Recommendation Report

AW/5/13

New barrel vault roof light, new marley cedar weatherboard cladding, soffits and fascias, re-arrange position of existing rooflights and repairs to existing chimney (additions to previously approved planning permission AW/140/10/)

33 Aldwick Avenue Aldwick

DATE Aug 12	DRAWN AS	CHECKED -
JOB NUMBER 3106	DRAWING NUMBER PR 11	REVISION A

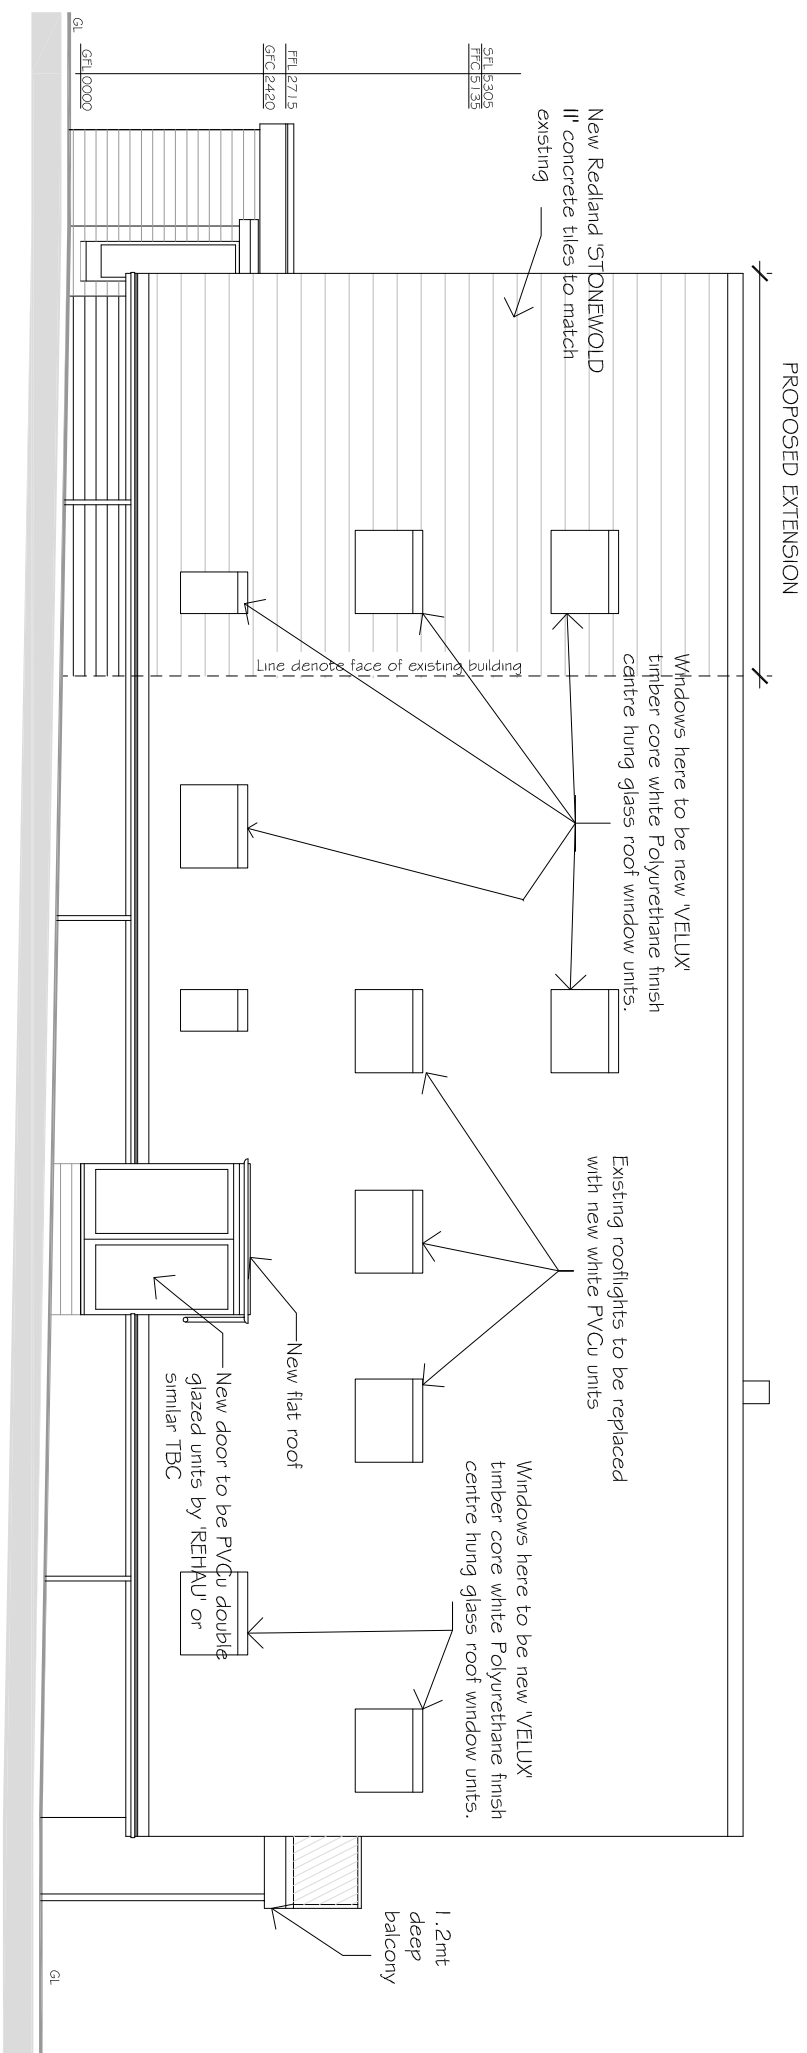
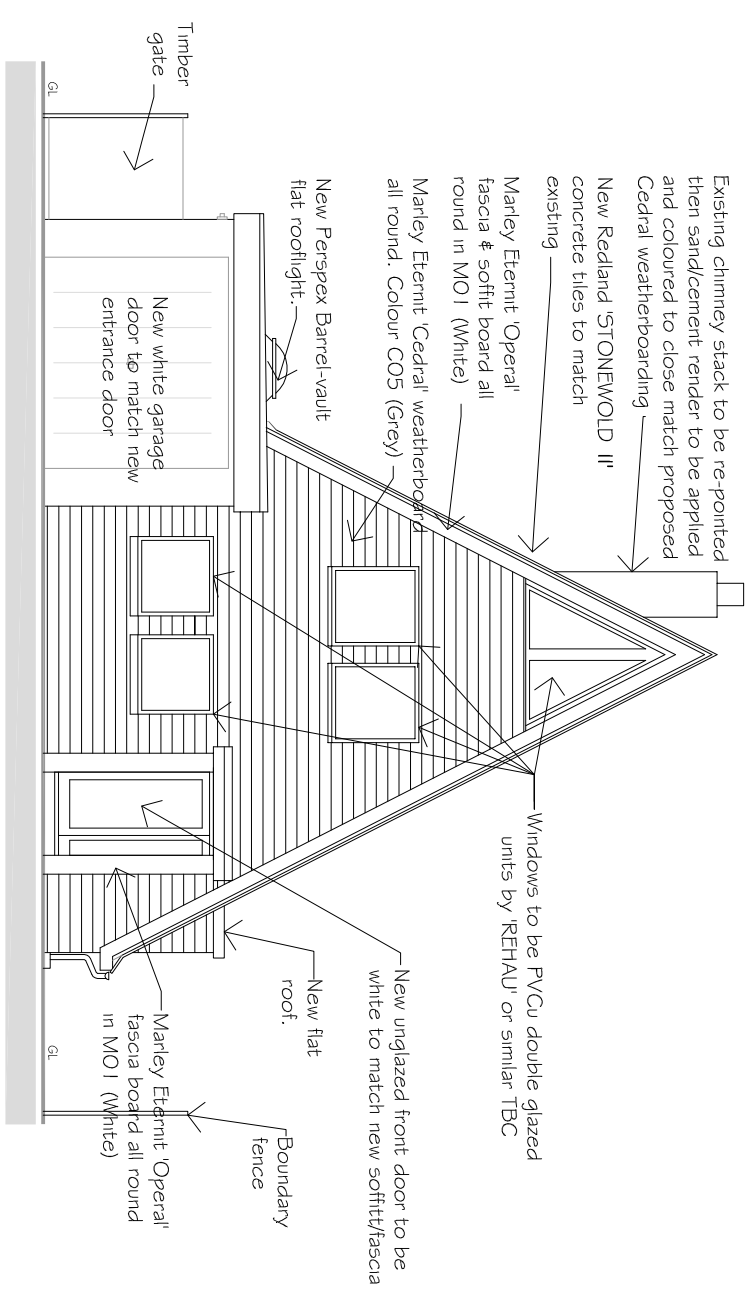
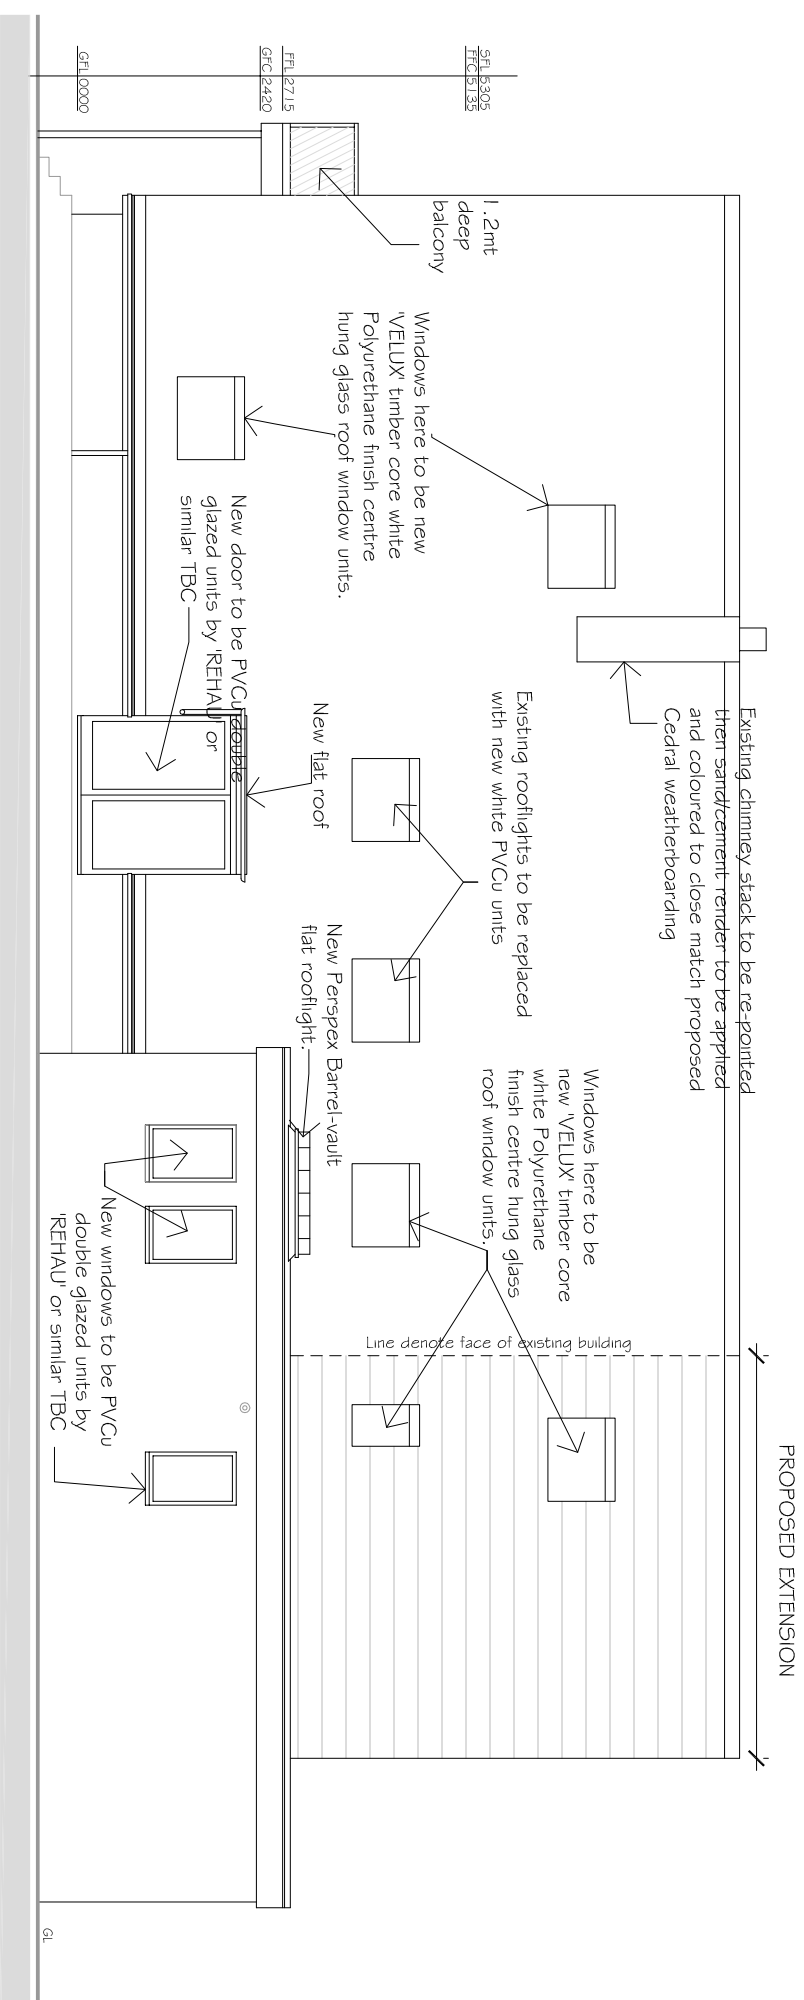
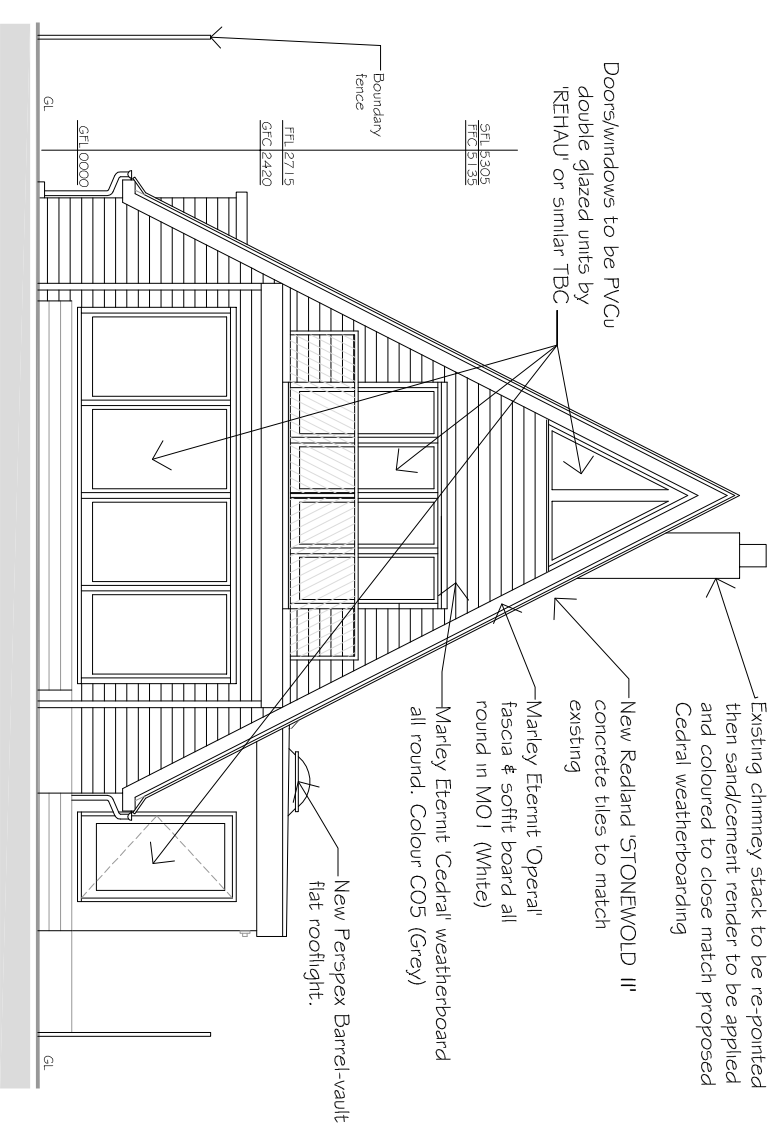
The elevations on plan PR11 has two plans labeled as proposed West elevation. Please amend accordingly. ✓ 22/1
